Craigweil House and its Environs

AW-267-15 - HH – Objection to roof change and cladding proposals – 15-10-15

**OBJECTION to AW/267/15/HH - replacement of clay tile roof and proposed
cladding and cladding colour – 68 The Drive – within the
Craigweil House Conservation Area and Craigweil House Area of Special Character**

PROPOSED NORTH ELEVATION 1:100

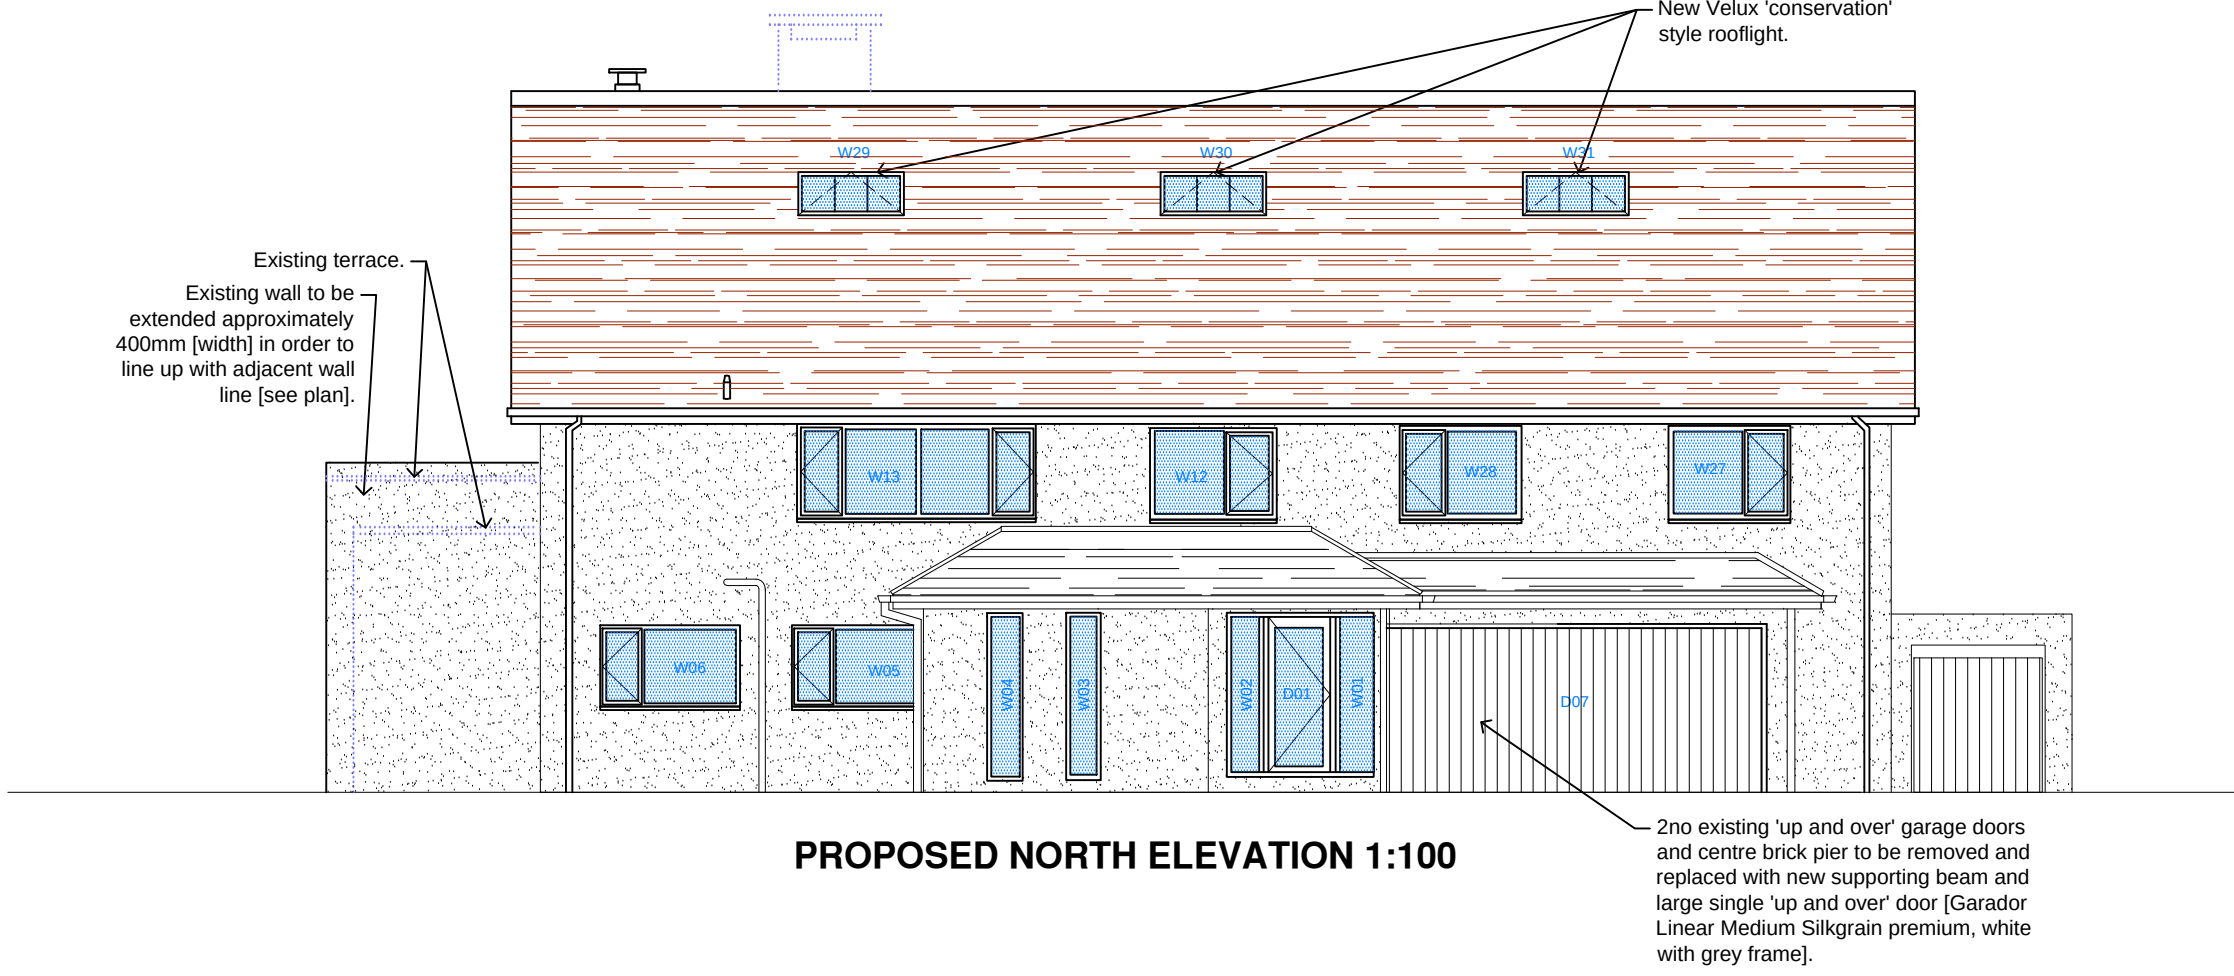
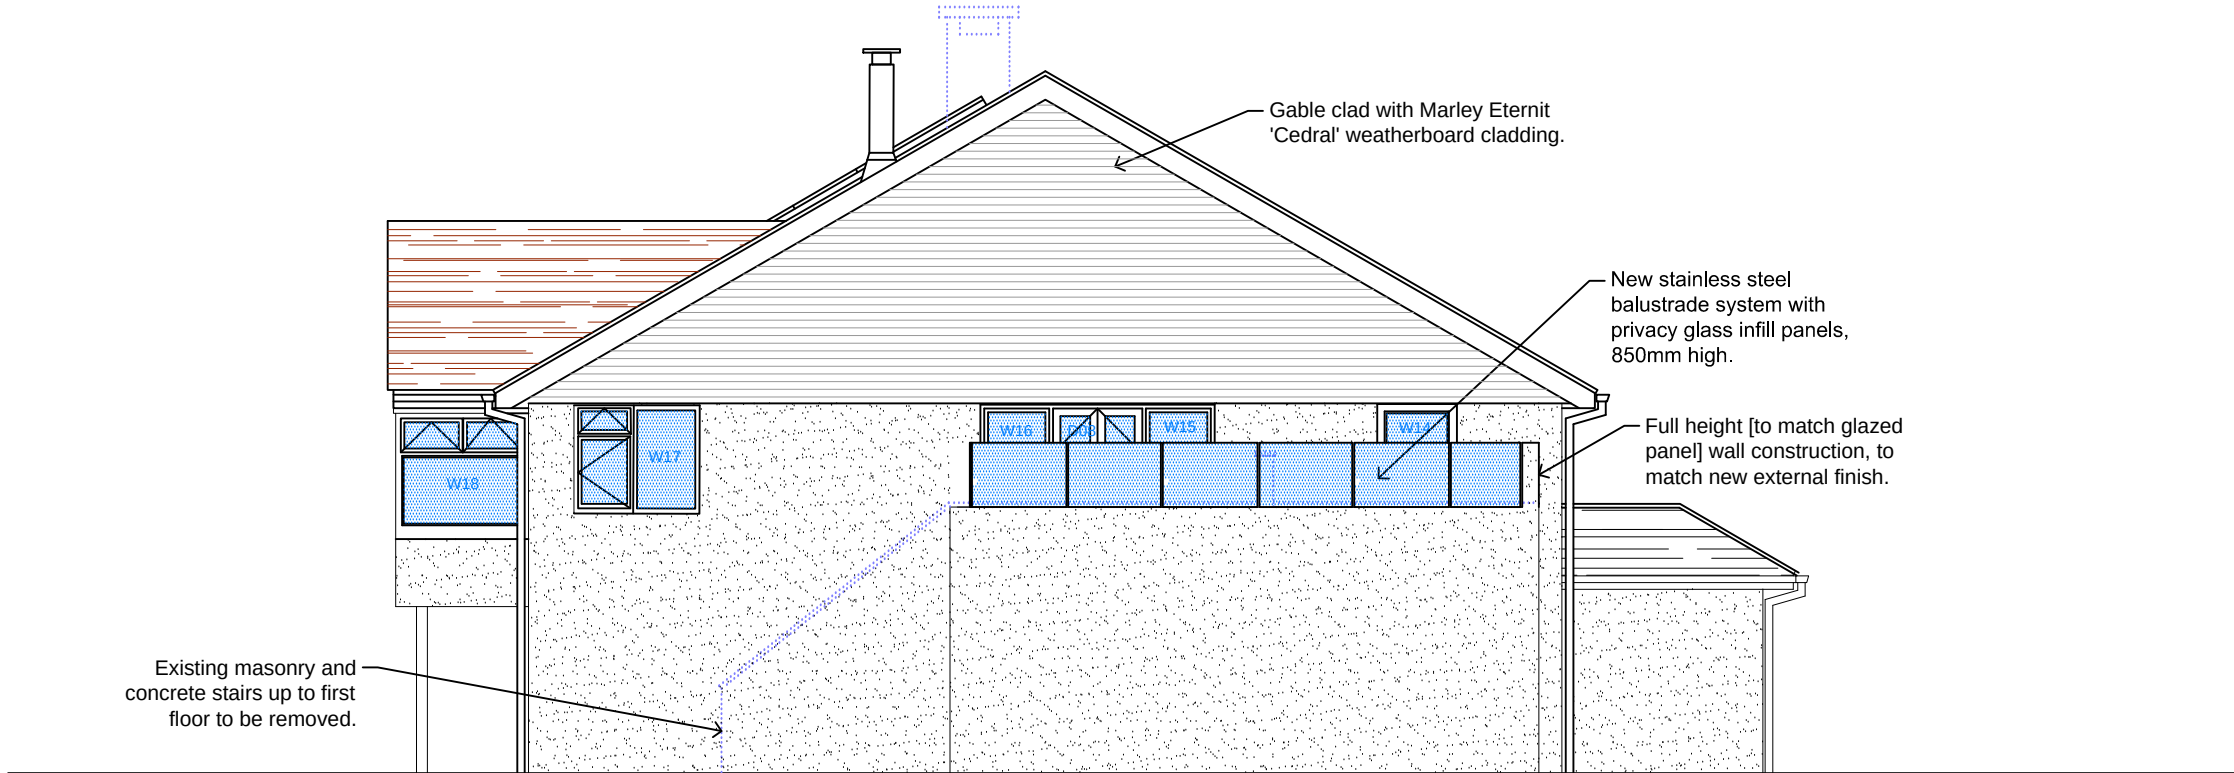
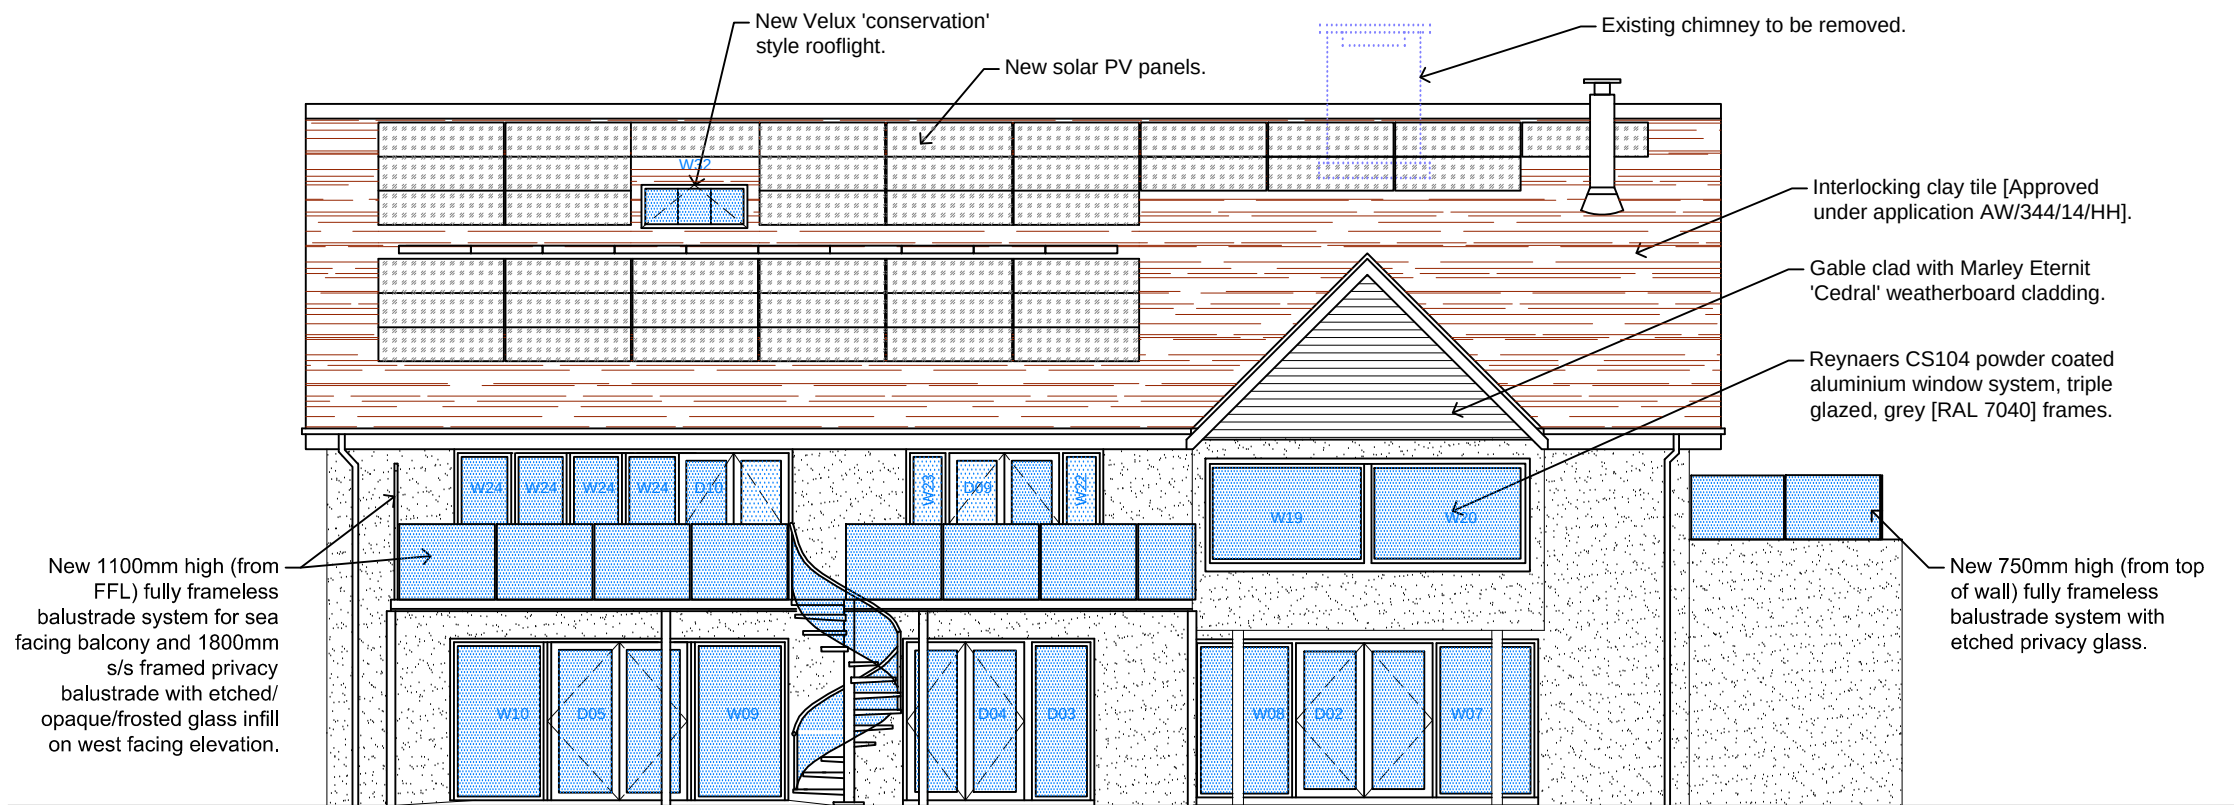
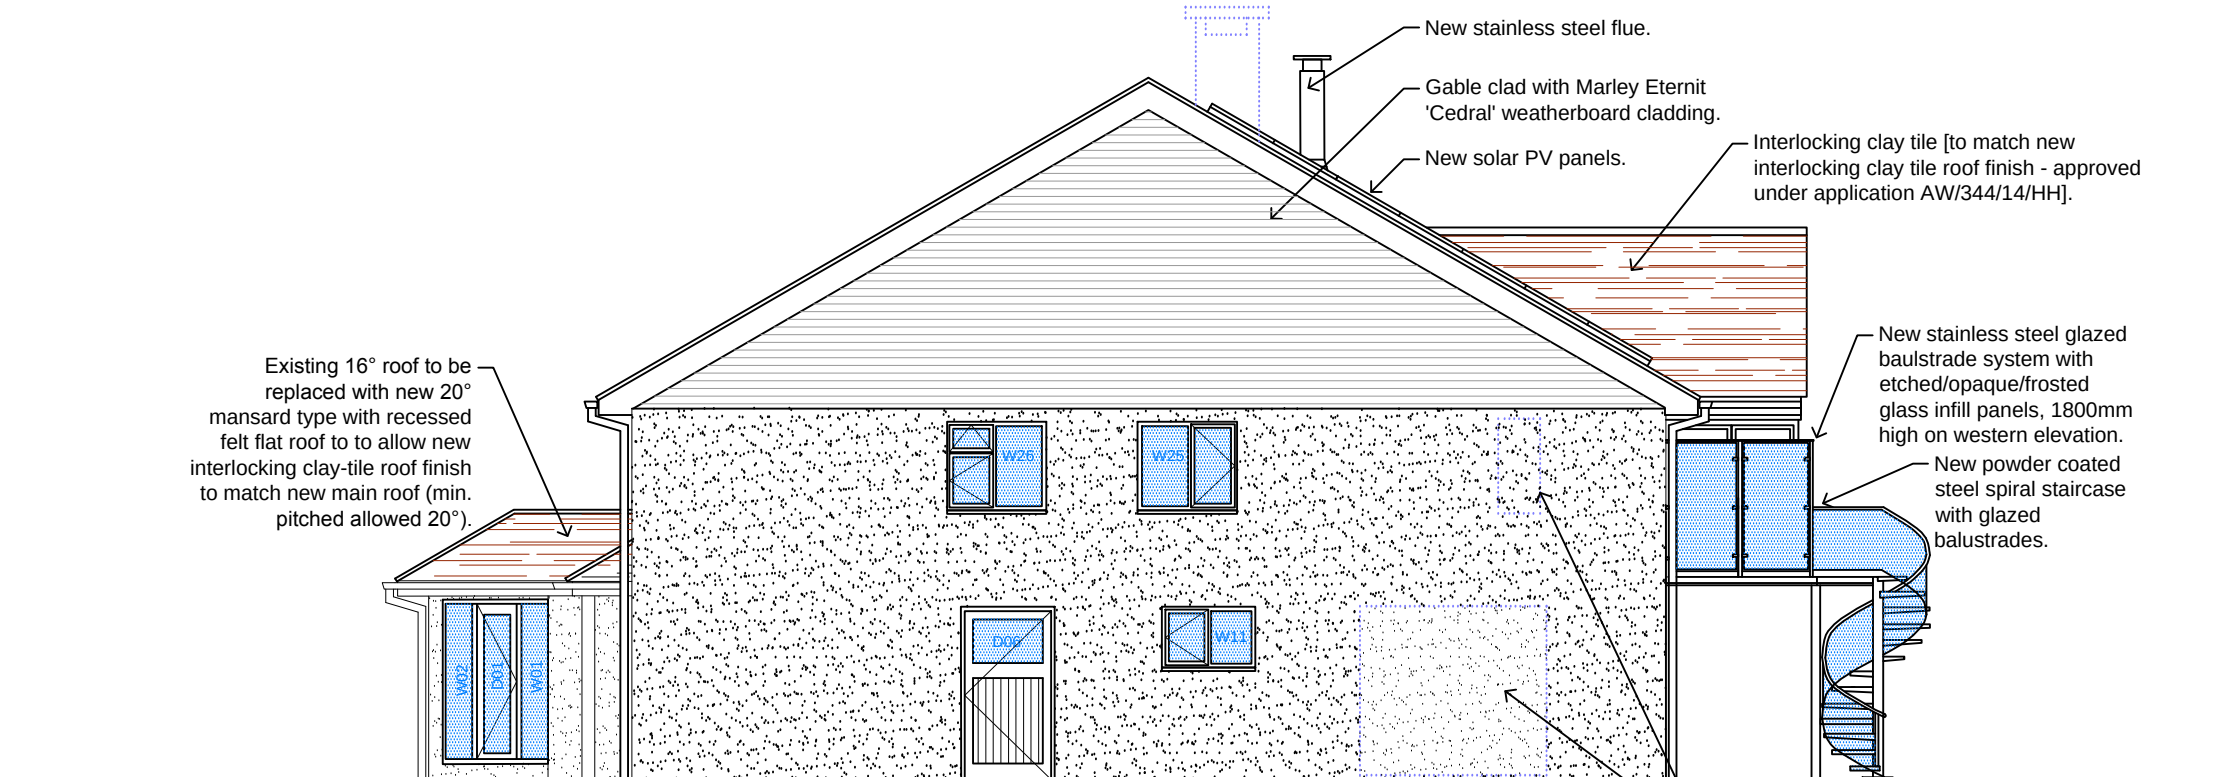
At once, it has to be said that the stark and we say harmful effect the change of colour of 68 to GREY will have upon the Conservation Area generally and the Heritage Asset, in particular, will be extremely damaging to the setting of 66 and have a severely adverse effect upon the conservation area in general.

We say that it has no place in this CA and that the colour should be required to be sympathetic to the heritage asset next door, 'Shore Cottage'. Within the overall design, which we had closely studied, we find no aspect that reflects the character of architectural style that was the origin of Craigweil House CA. We say that the total absence of any attempt to enhance the area should weigh heavily against the approval of this application.

It is proposed that there be *‘Installation of LED downlights into the eaves soffit at 2m centres.’* and we say that this would radically degenerate the general standard of the conservation area and leave the property looking more like a low class, downtown, 24 hour drinking bar and night club than a high class residence on a most important south coast marine estate steeped in regal and architectural history. Such a tawdry addition can have only a negative impact on the conservation area and impact negatively and cause harm to it. It certainly neither preserves nor enhances the character of the CA nor makes a positive contribution to the ASC. And it flies in the face of GEN7 which stipulates that *‘Planning permission will only be granted for schemes displaying high quality design and layout.’*
